# City of Ryde

**Proposed Residential Development (Phase 1) and Road Construction  
on the Royal Rehabilitation Centre Sydney site at Ryde (MP10\_0189)**

**ATTACHMENT: City of Ryde submission for Phase 1 Residential for Royal Rehabilitation Centre Sydney and construction of Road 5 (MP10\_0189)**

MINOR COLLECTOR ROAD

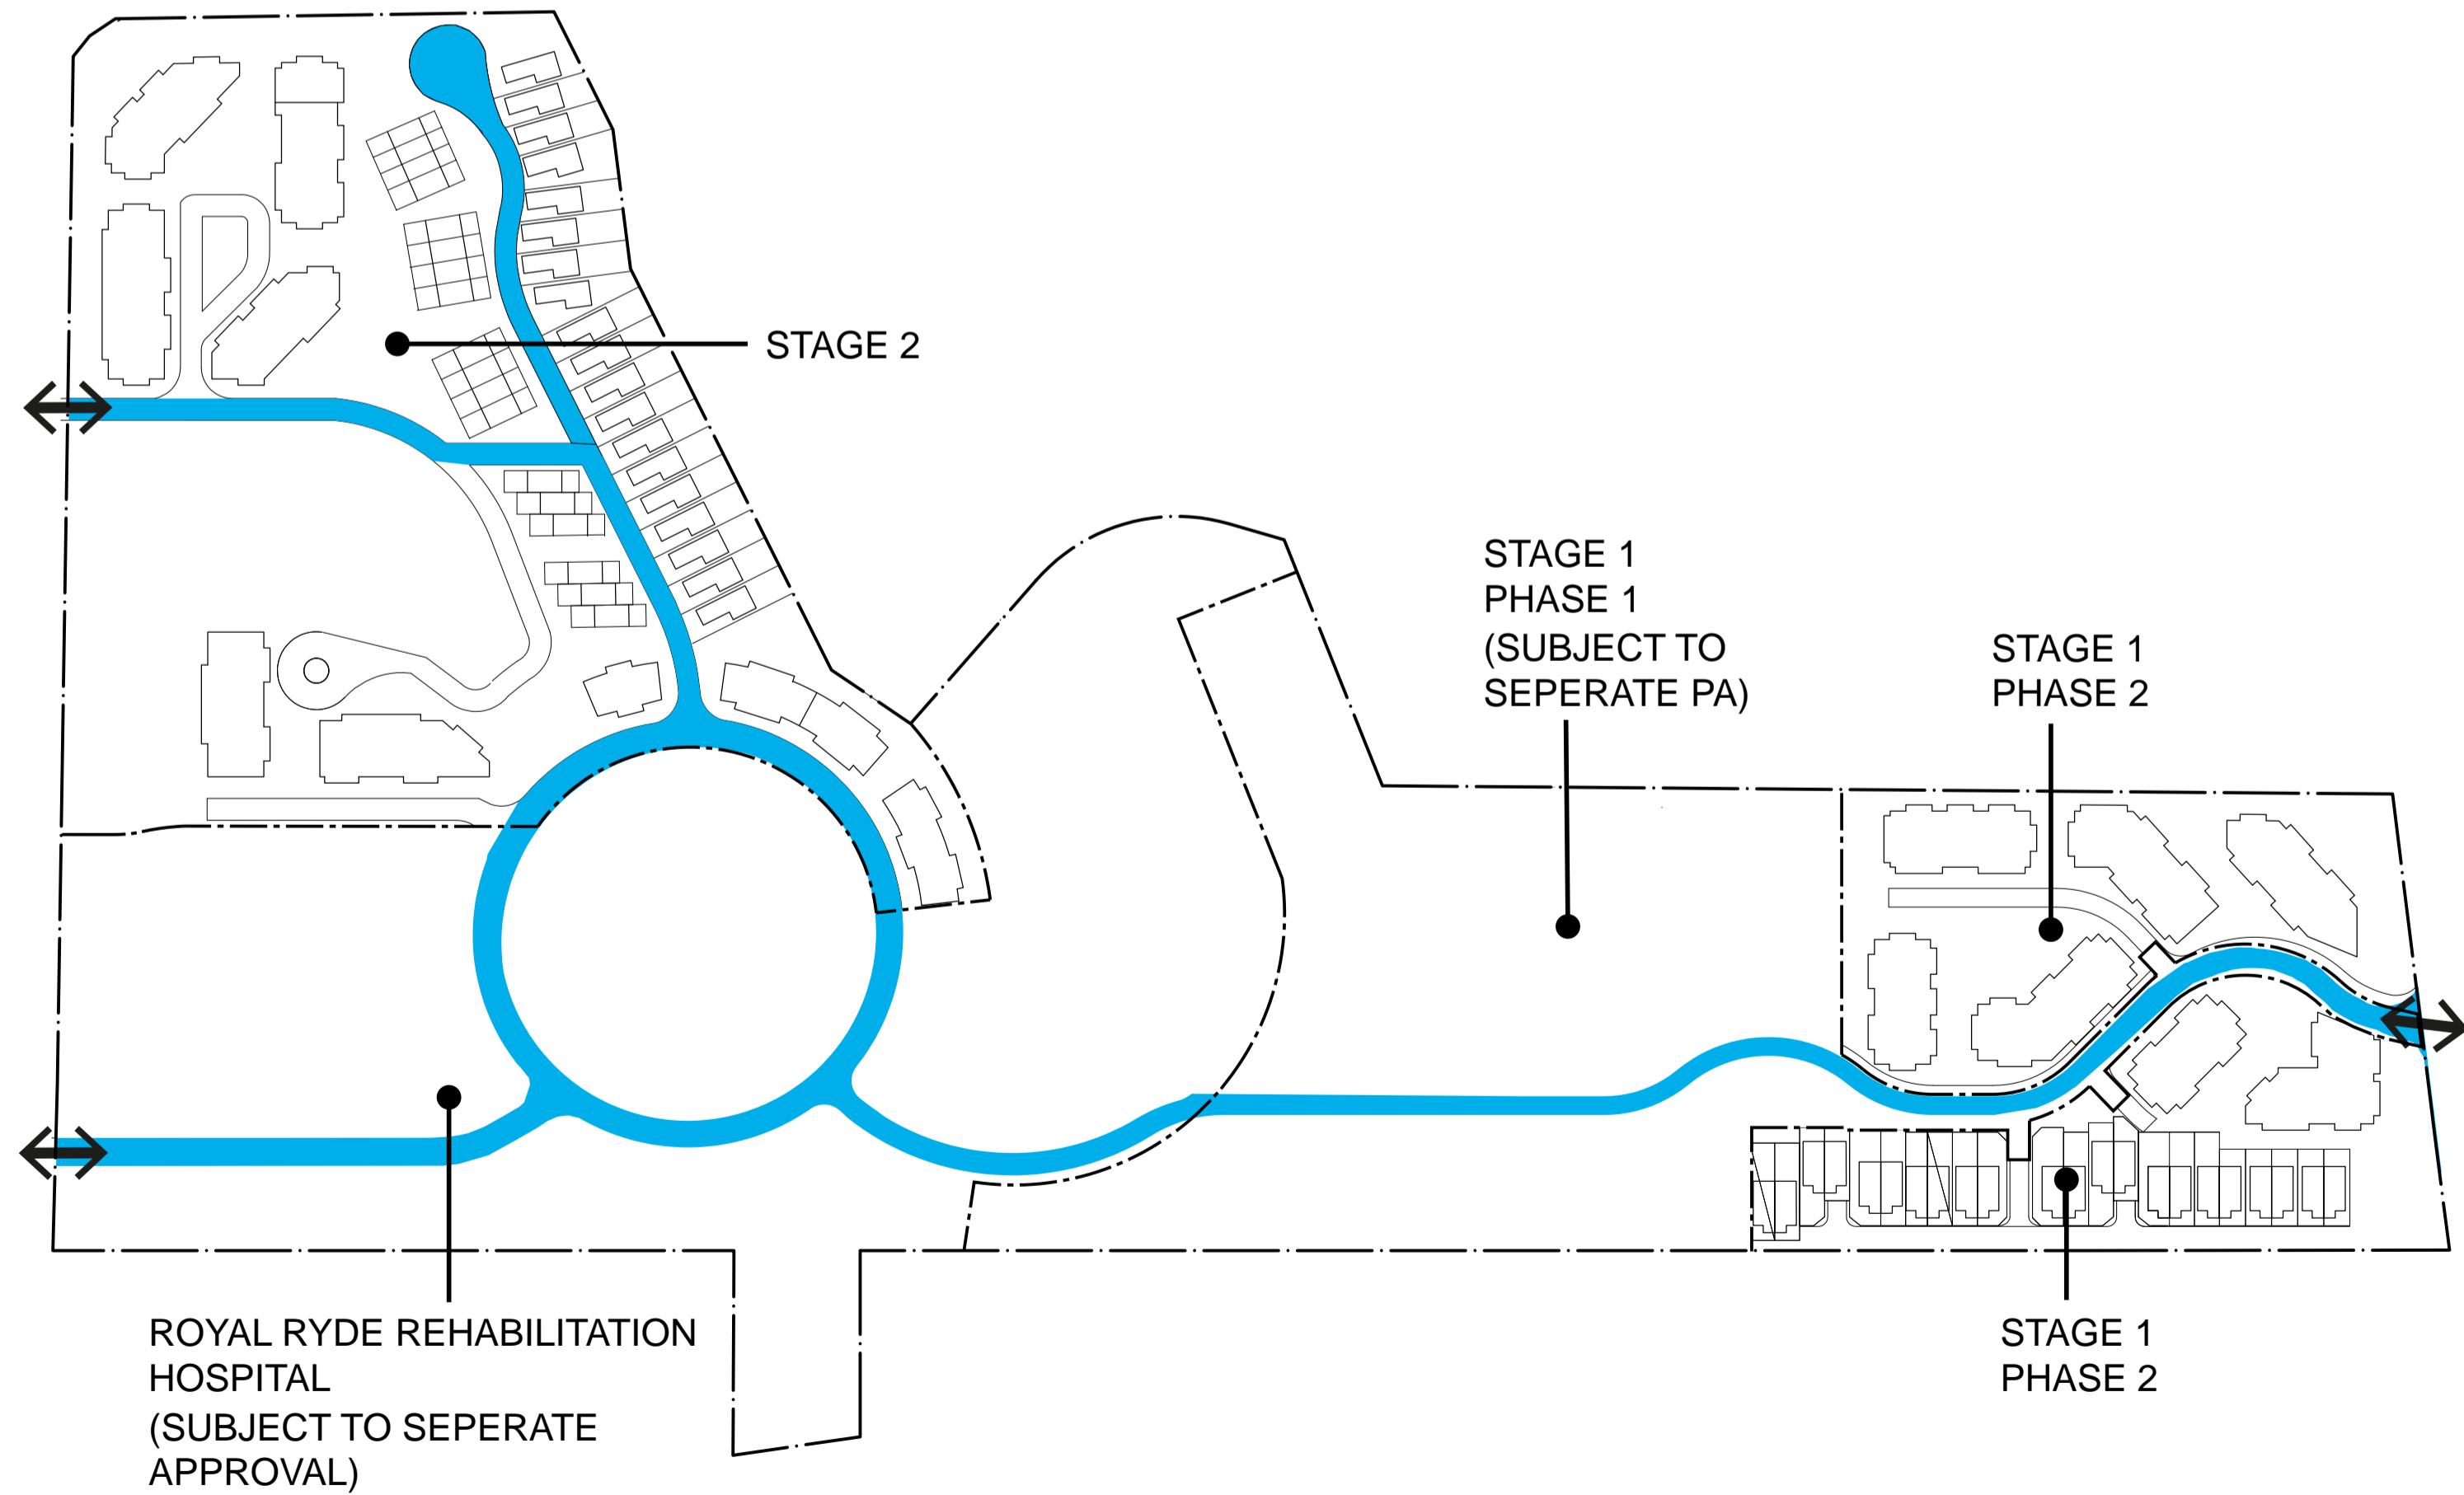
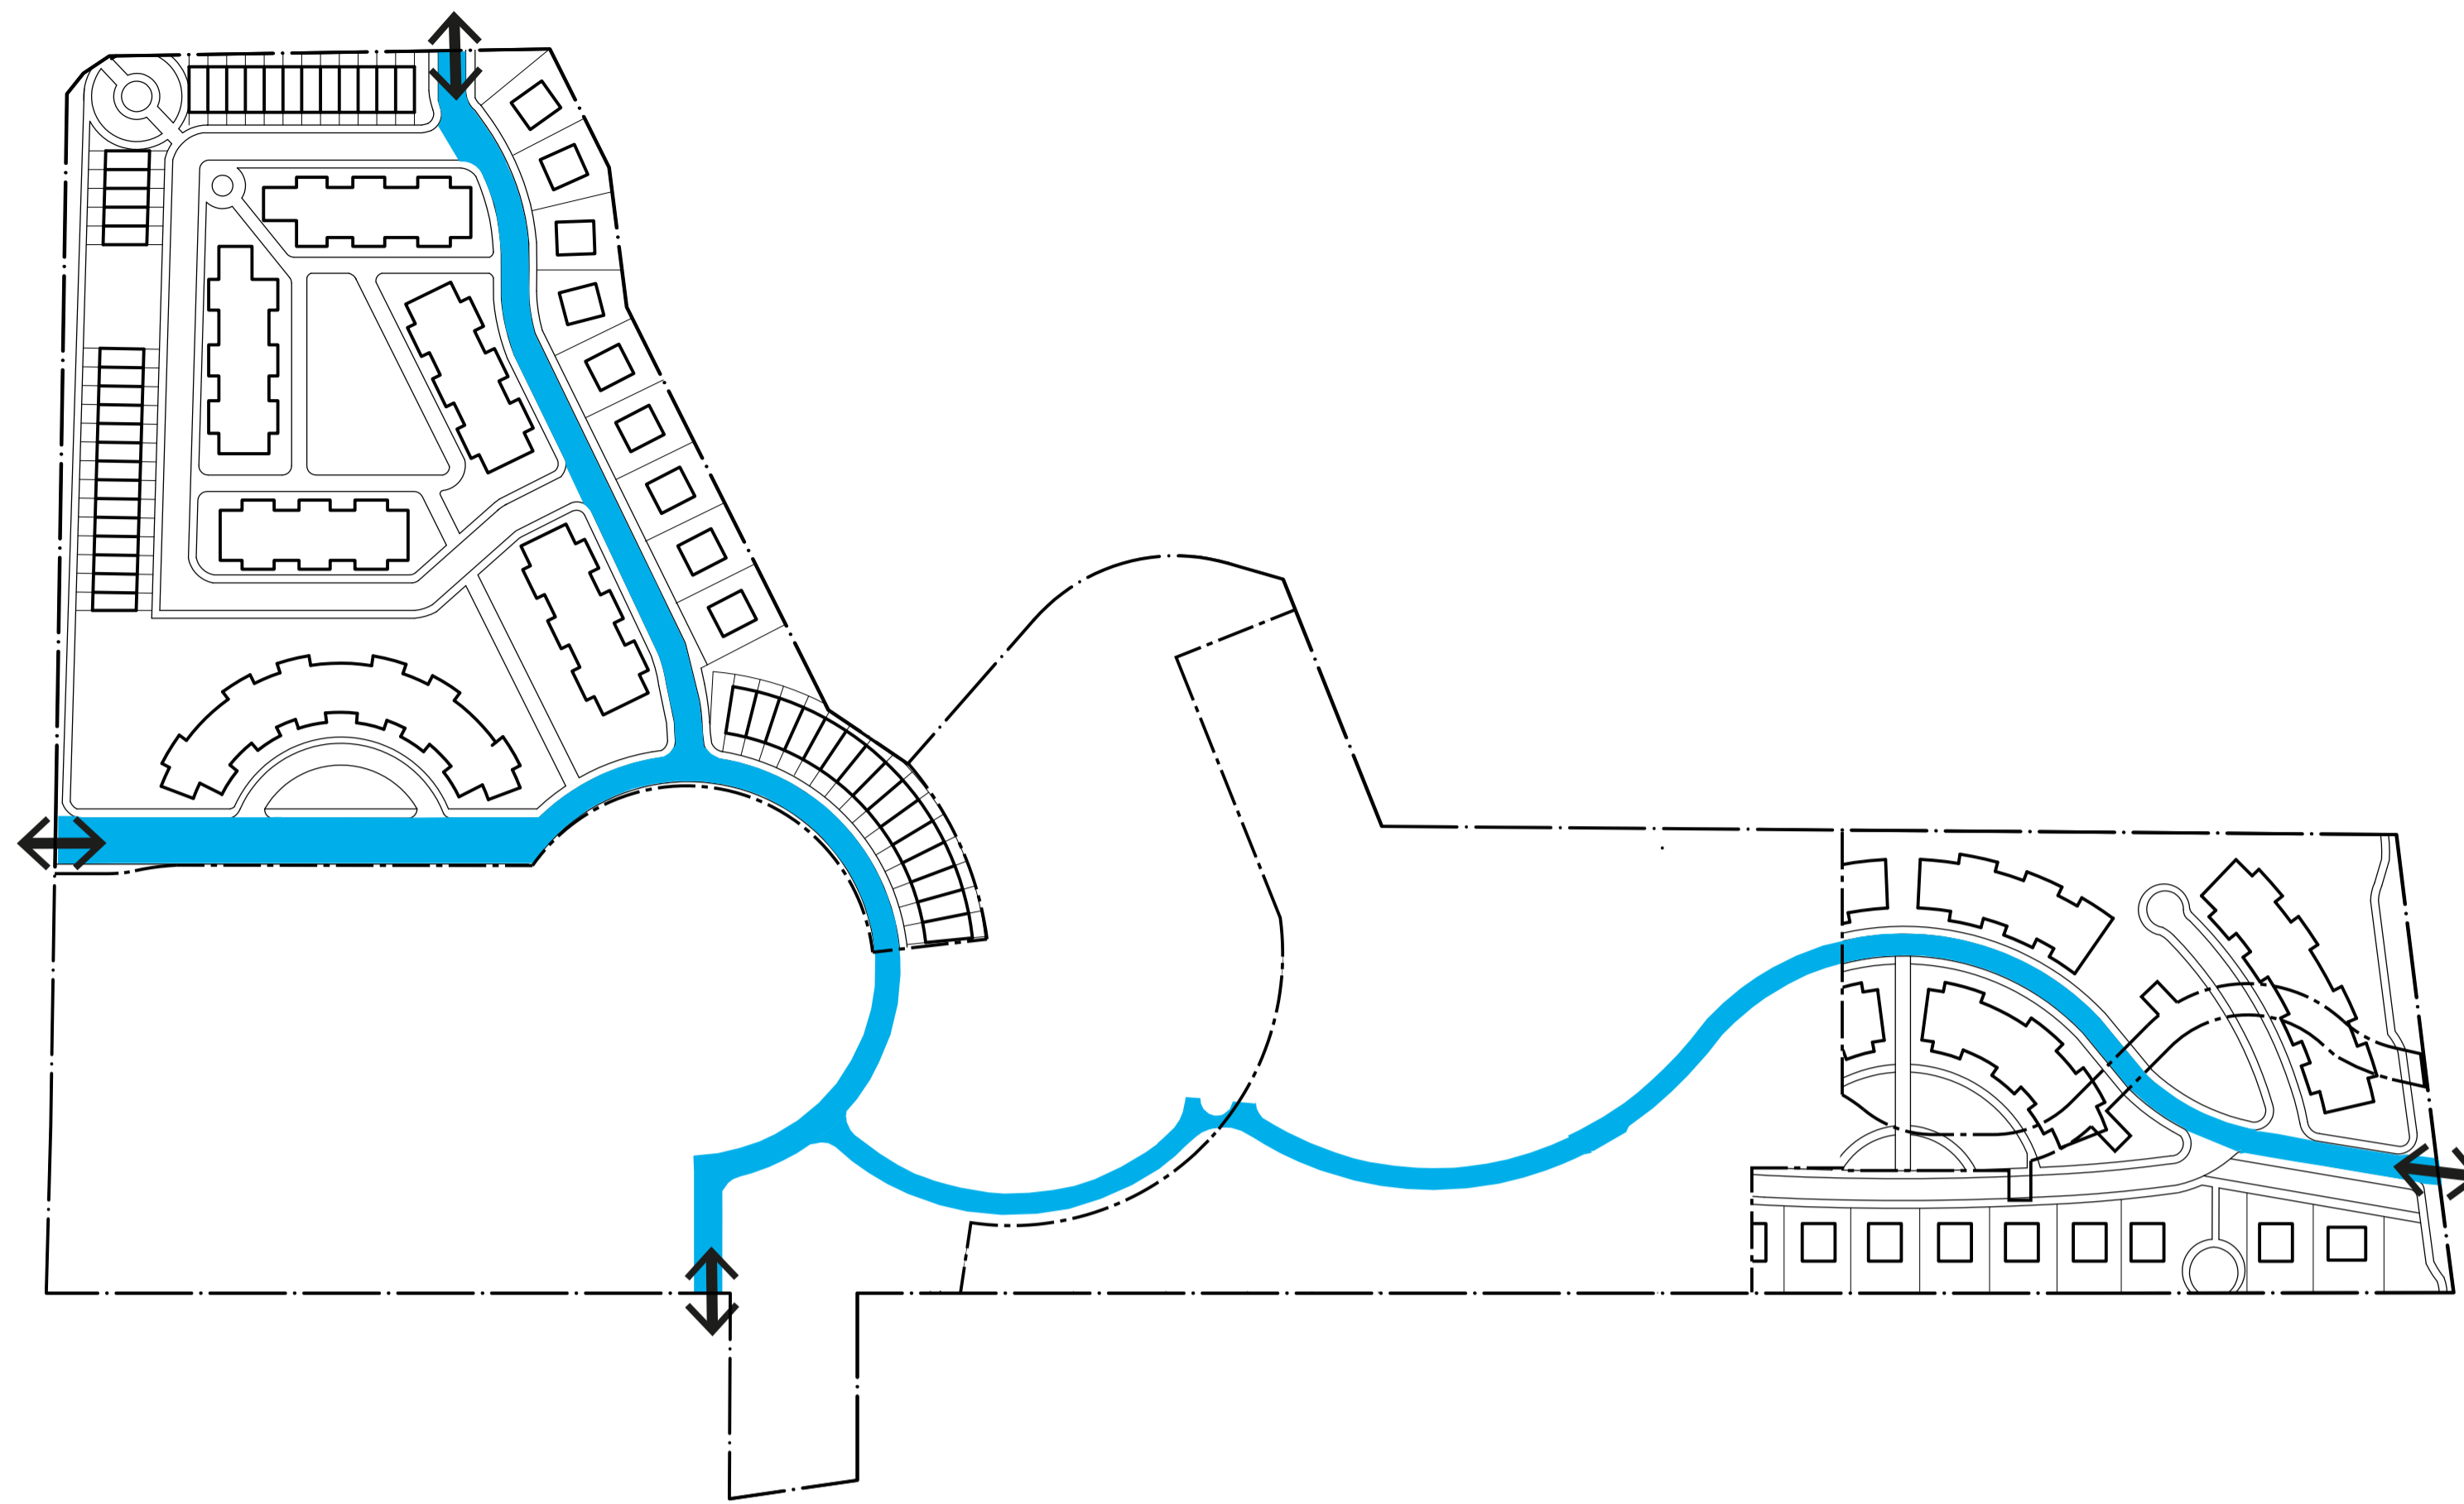
<p><b>CONCEPT PLAN</b></p>	<p>A concern with the revised Concept Plan contained in the submission prepared by JBA Planning for the whole site is an apparent shift from a road layout with a connected through road design to one which provides less site connectivity. A focus on providing good connectivity and permeability are features of transit oriented development and in Phase 1, it is noted that Road 8 connects with Roads 4 &amp; 5 and Road 4 provides connection to the “central parklands area. However, for later stages of the RRCS development, a similar level of connectivity is not demonstrated and it is unclear what the impacts on the final through site navigation will be and how it will consequently impact on internal pedestrian movement and traffic impacts on the adjoining road network. Further, Council requests that for Phase 1, the Department give consideration as to whether the private “rear lane access” provided for lots adjoining existing properties in Charles Street provides the optimum layout for safety, waste collection, emergency vehicle access and privacy. This consideration should have regard to the slope of the land in this location and the relative ground levels for existing and proposed dwellings.</p>
